PLANNING AMENDMENT

PLOTS 5 & 6, STONEGATE, GEDNEY

H06/1251/98

BUNGALOW ON PLOT 5 CHANGED
TO 'ULLSWATER' DESIGN.

AMENDED PLAN

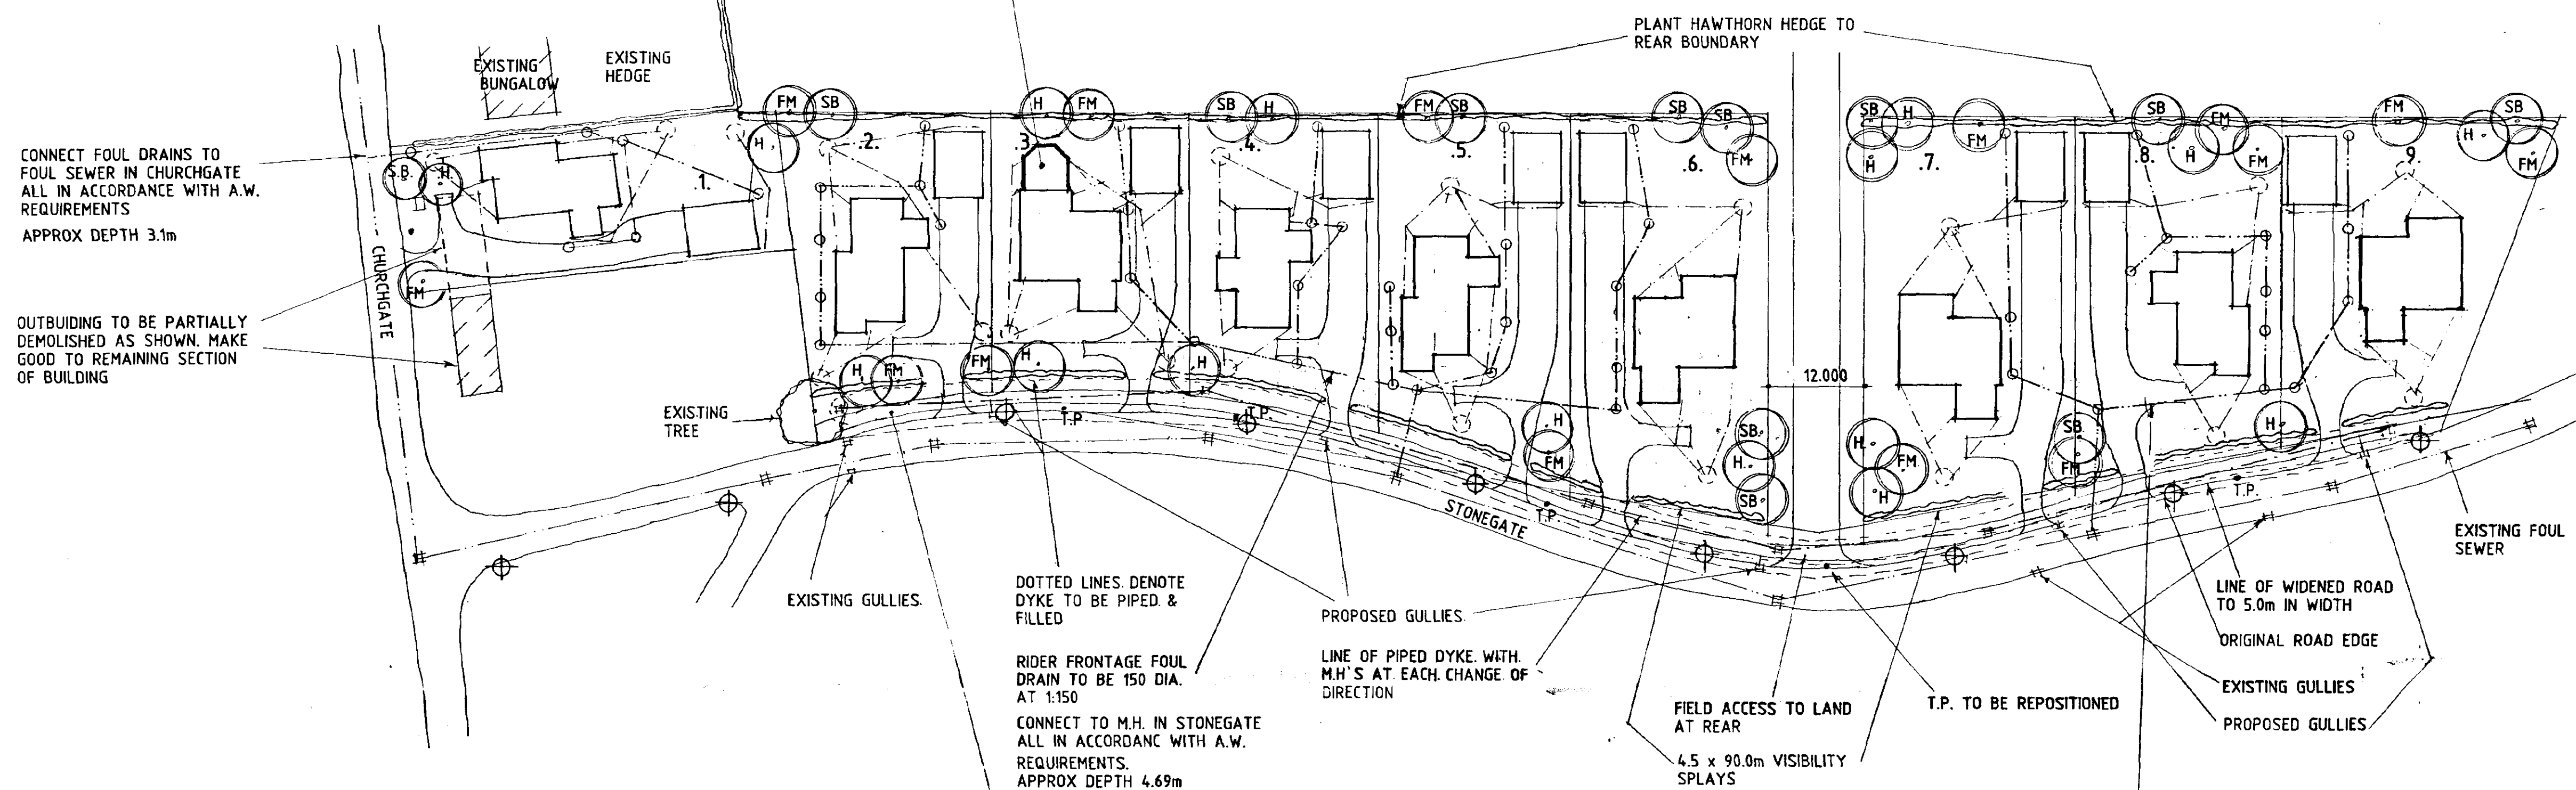
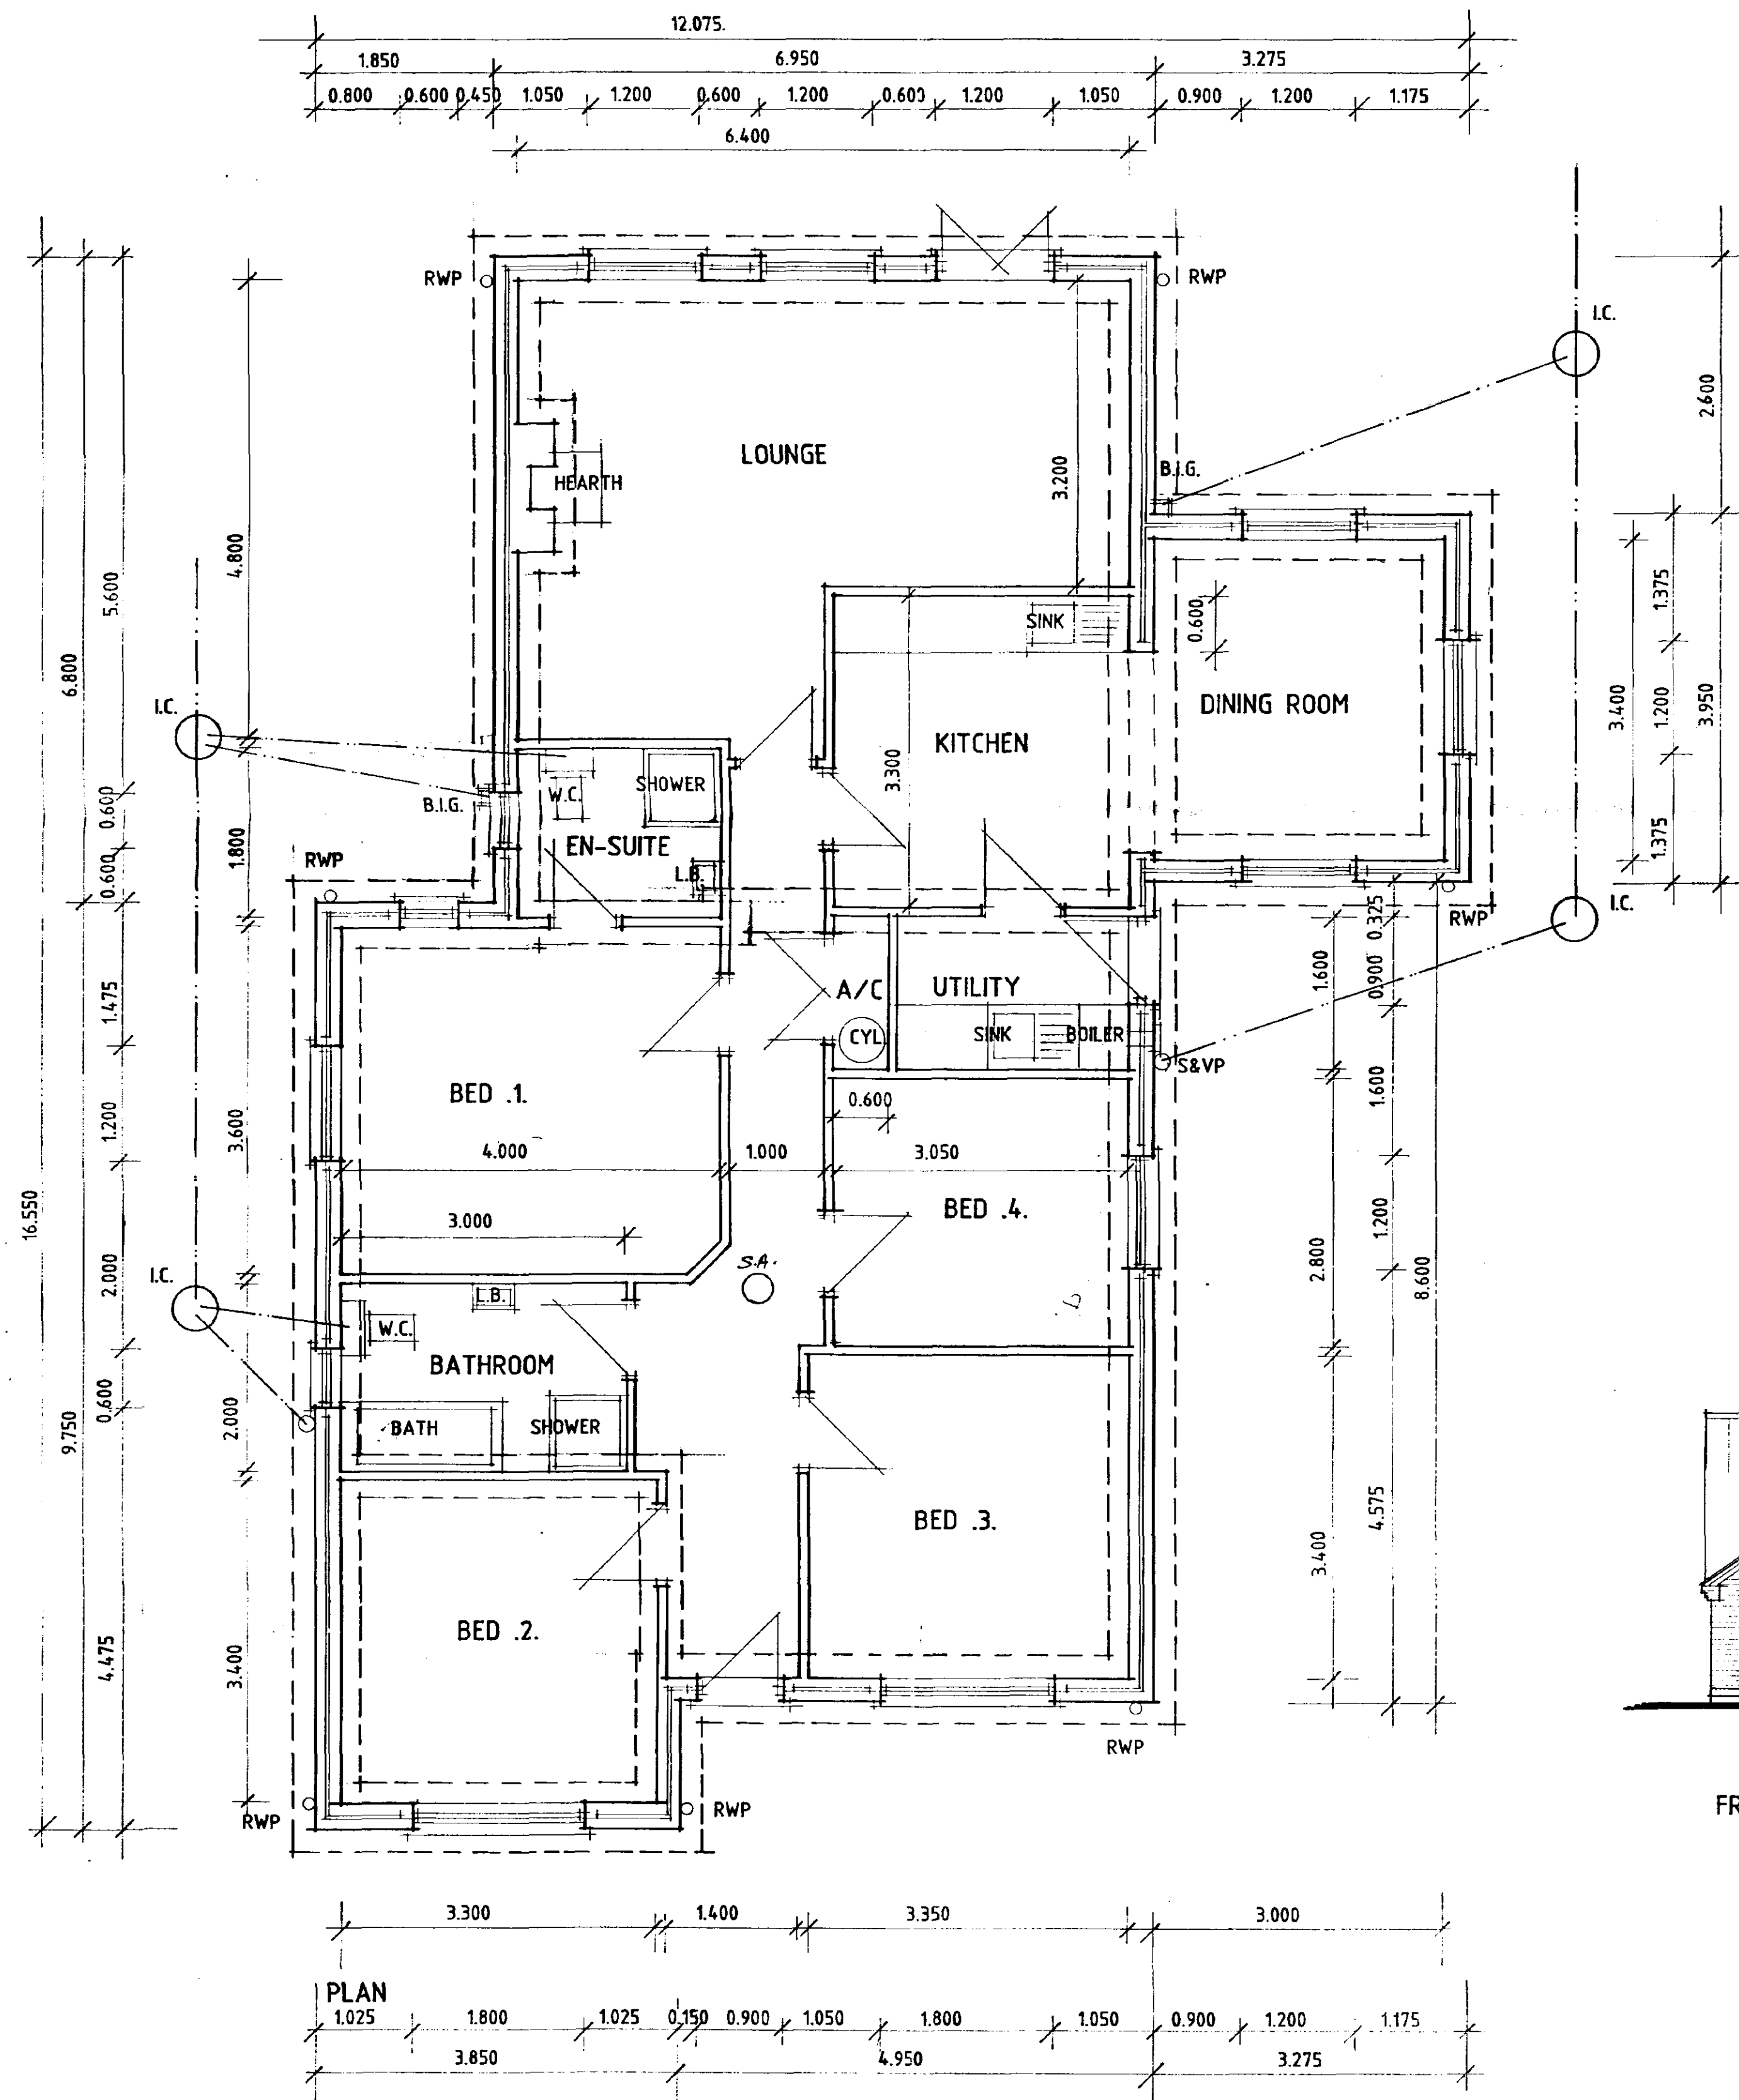
BUNGALOW ON PLOT 6 CHANGED
TO 'LANGDALE 2' DESIGN
